Written Representations on the dDCO – Rule 8

17th December 2019 by Mr and Mrs R J Cowell residents of [REDACTED]

[REDACTED] Ref: M25J10-AP053

SHEET 2 OF 31

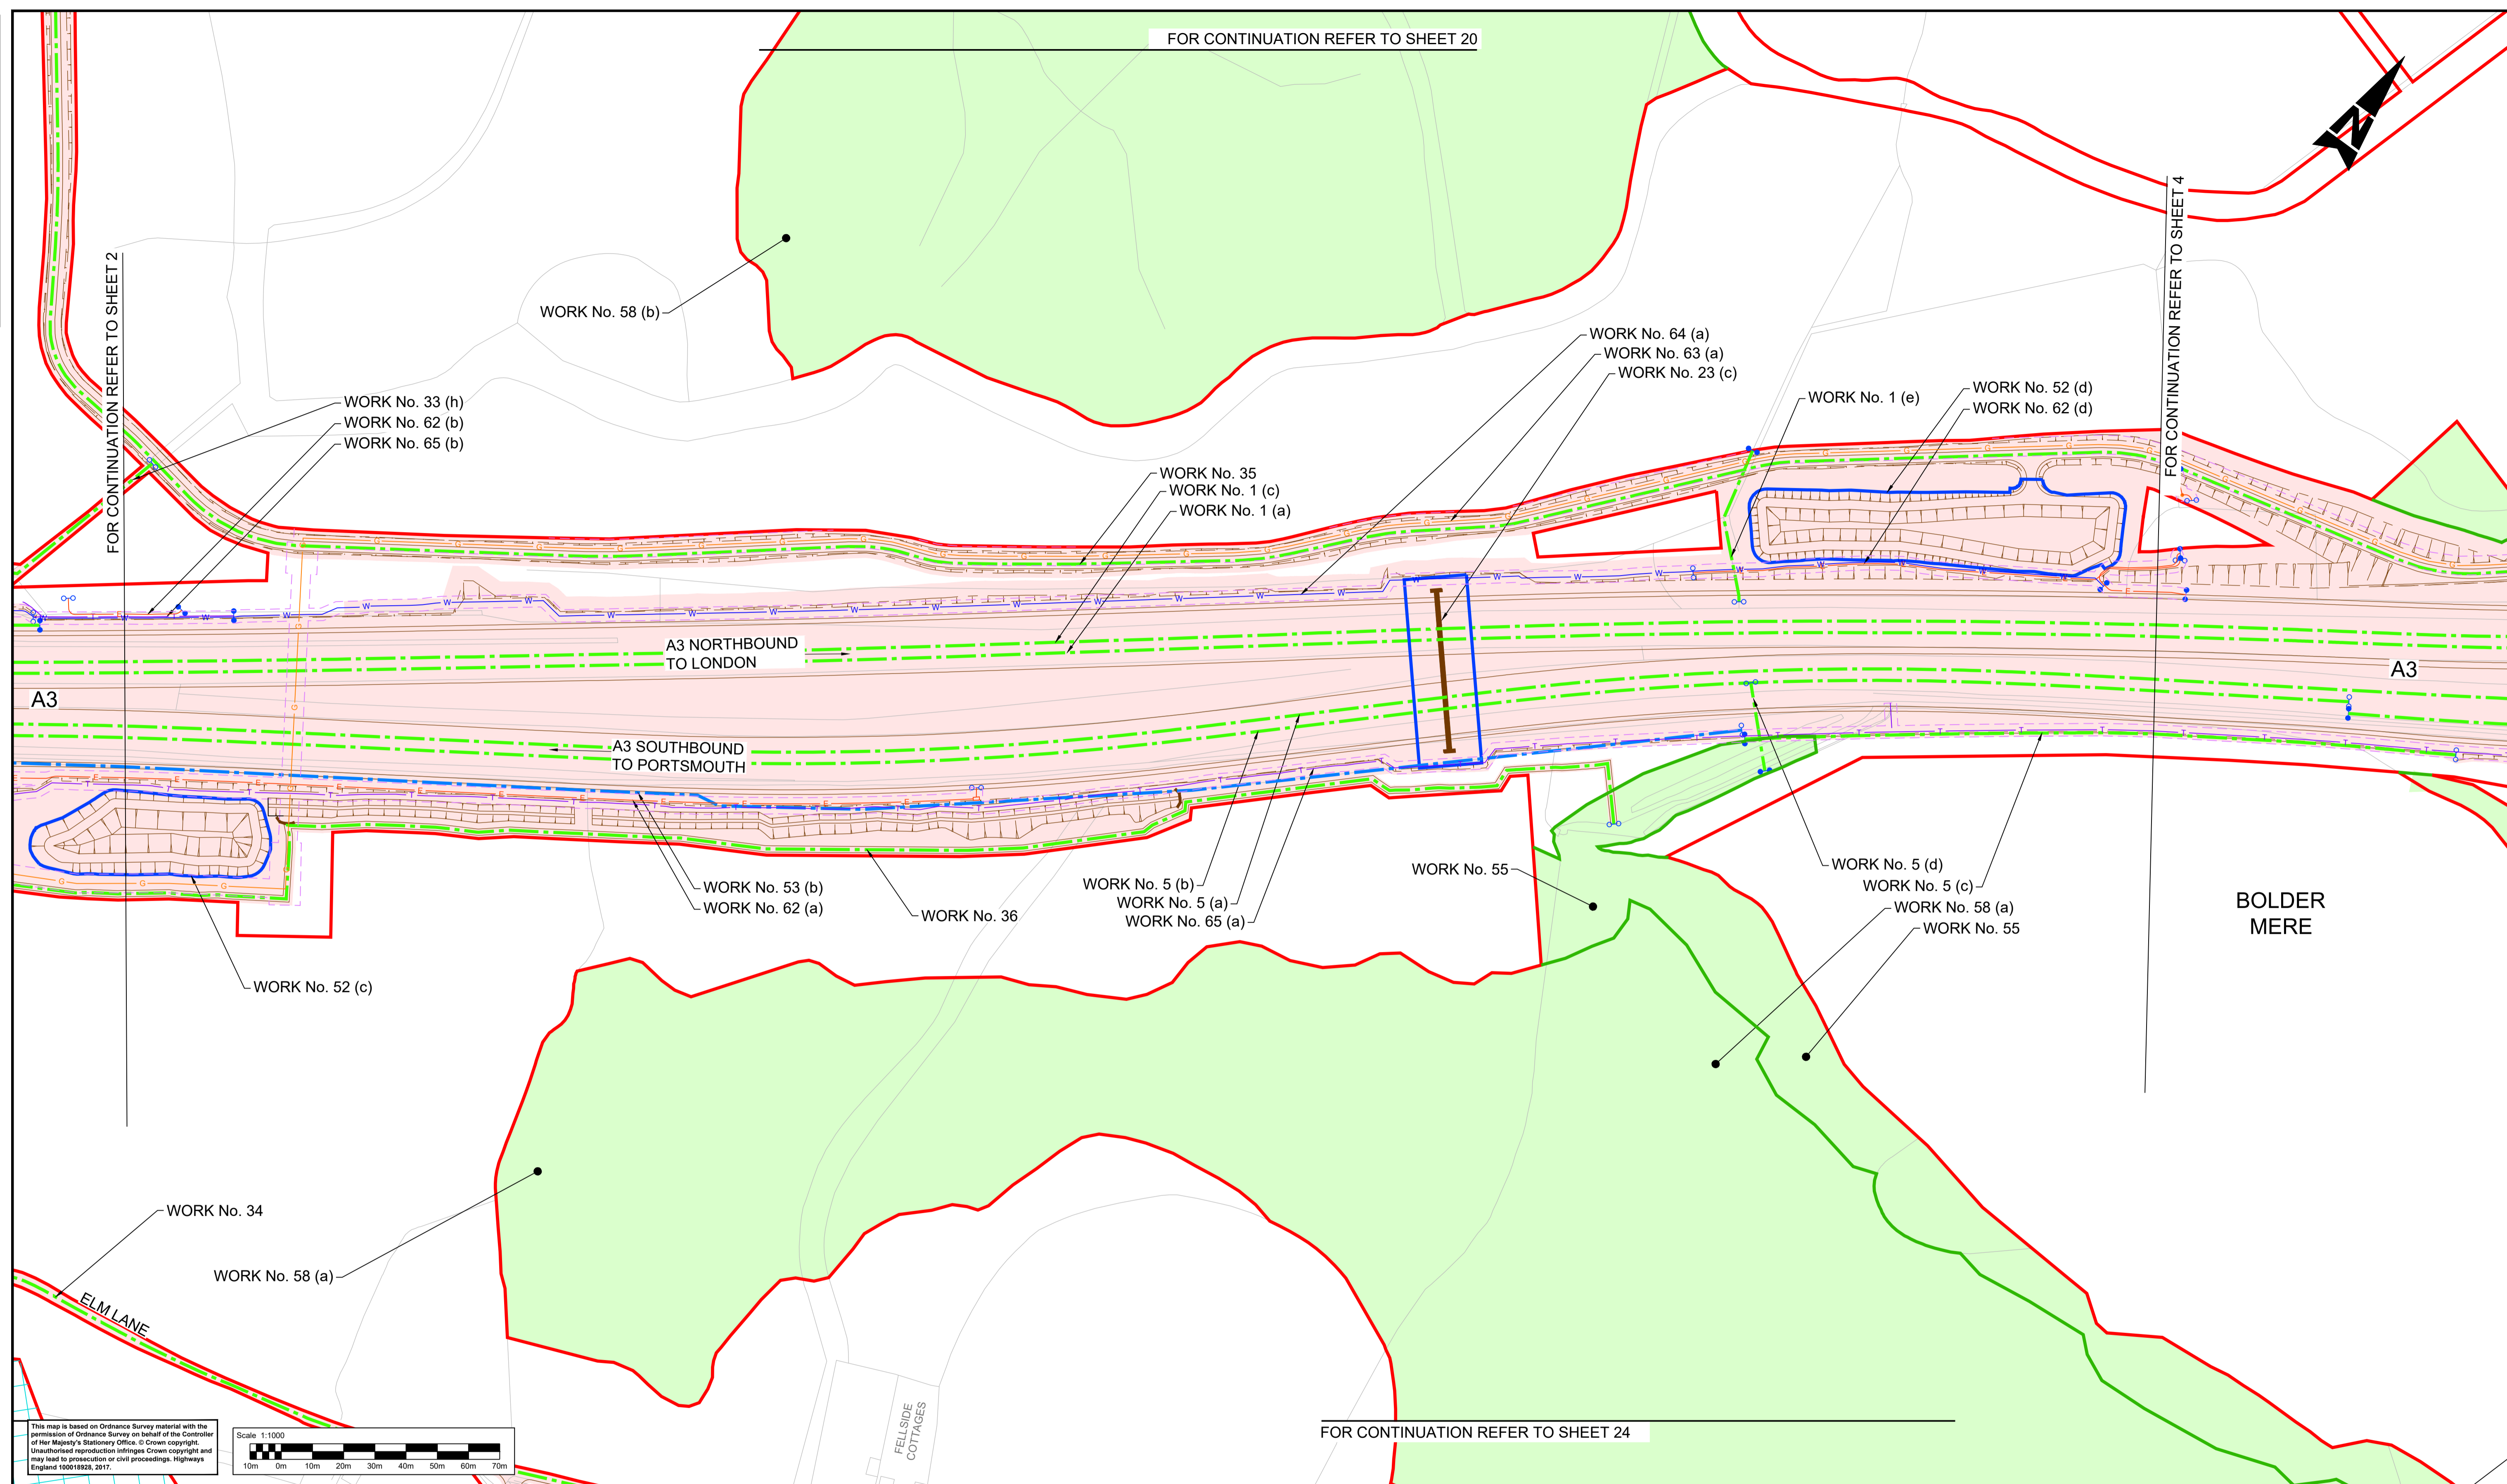
I would ask the Inspector to look at APP-012 Scheme Layout Plans sheet 2 of 31 HE reference: TR010030/APP/2.8 which clearly shows the current central reservation between the north and south bound carriageways of the A3. There is a large area of redundant scrub land which would allow the northbound A3 to be effectively moved away from the RHS Wisley boundary fence and allow space for an access road into and out of RHS Wisley without the need for the expensive and excessive over bridge. This solution does not seem to have been explored by Highways England or their ecologists, it could accommodate large monetary savings in the project and ecological savings for both woodlands and the SPA. The photo below shows the wasted central reservation scrubland.
